JULY 2, 2010

RE: Review Comments for Final Plan – Administrative Review

Project Name: Riverside Wood/Millwork Shop
Project ID: 10-79900010
Project Address: 828 Riverside St **CBL:** 325-B-008-001
Planner: Erick Giles, AICP, LEED AP

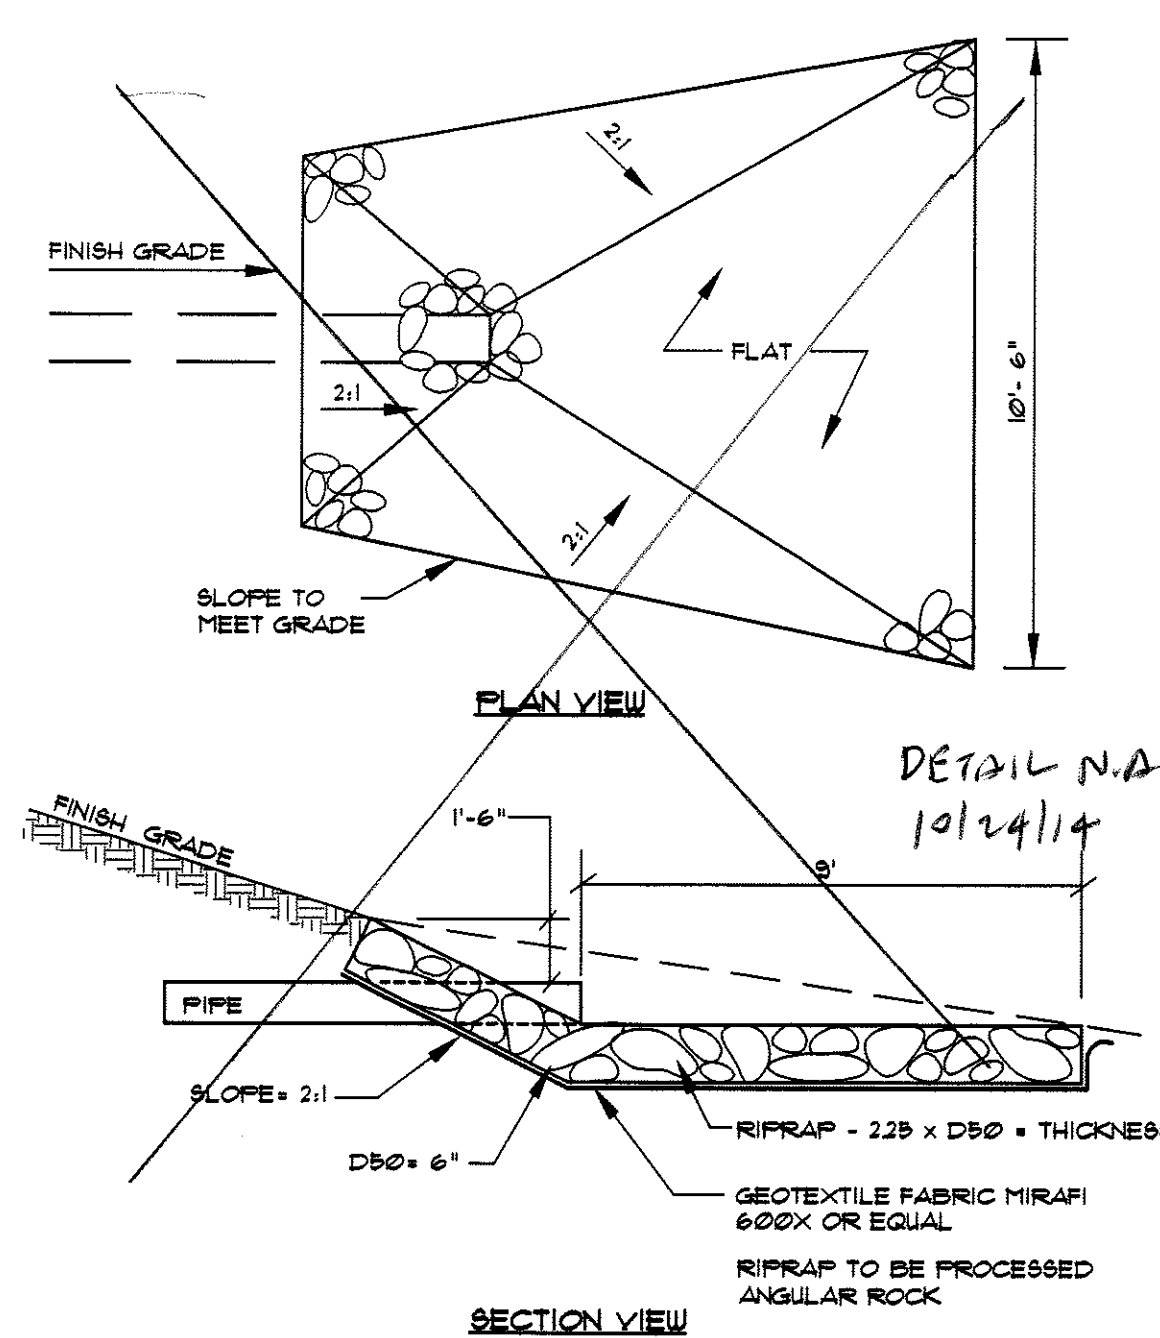
- i. Applicant needs to apply for a sidewalk waver if they do not intend to install a sidewalk.
- ii. Applicant current shows an approximate 10' x 10' shed within the View Street R-O-W. Applicant shall indicate that this shed will be moved onto the applicant's property within the required 10' setback line.
- iii. Applicant indicates the existing 25' wide driveway will be removed and replaced with a 20' wide driveway. Does the applicant intend to alter the curb cut to the street?
- iv. The applicant is requested to show how drainage from the site will be handled.
